Owner: Miguel Topete Torres  
(719) 217-4581  
miguel@nikelsplastering.com

Property Address: 5805 N Meridian Rd  
Parcel ID: 4318000006

Planning Comments for AL2212 - V1 - 7/11/22  
- Please include close up (zoomed in view) for the proposed contractor's yard.  
Outside Storage and Work Areas Allowed.

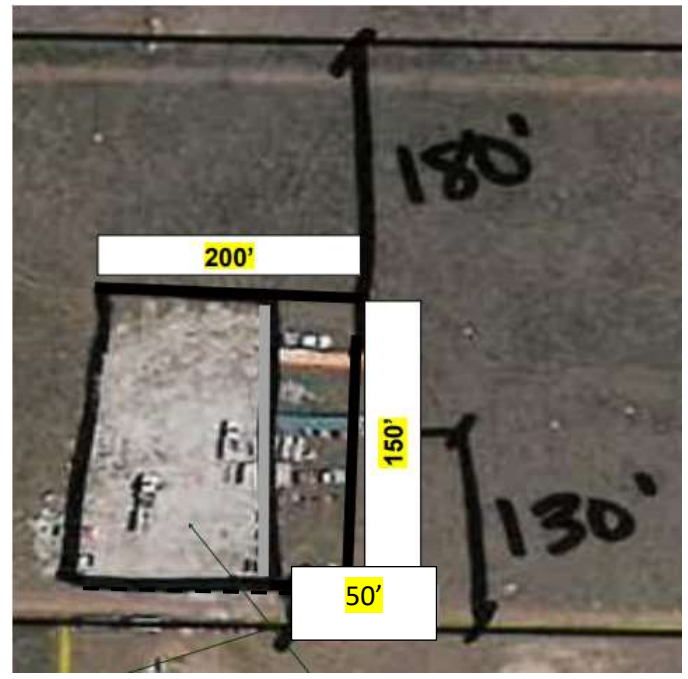
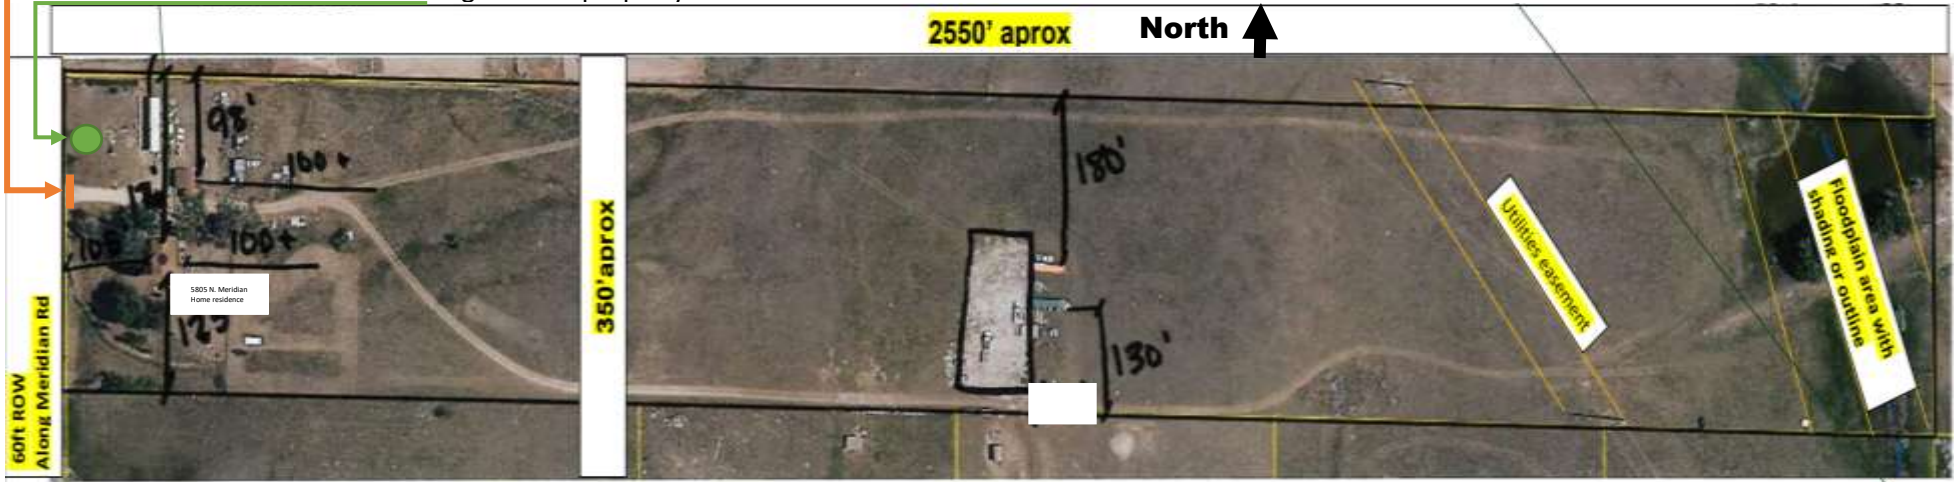
Please refer to site plan checklist to ensure all applicable information is annotated on site plan. Several items are missing as it relates to dimensions. Recommend enlarging site plan.

Provide profile view (example) of screening fence (height and type of fence construction) and provide/explain details in LOI

Add dimension of yard on all 4 sides

Denote 60ft ROW along Meridian Rd

Label residents

25ft setback <50ft required

Include lot dimensions

Indicate 100yr Floodplain area with shading or outline
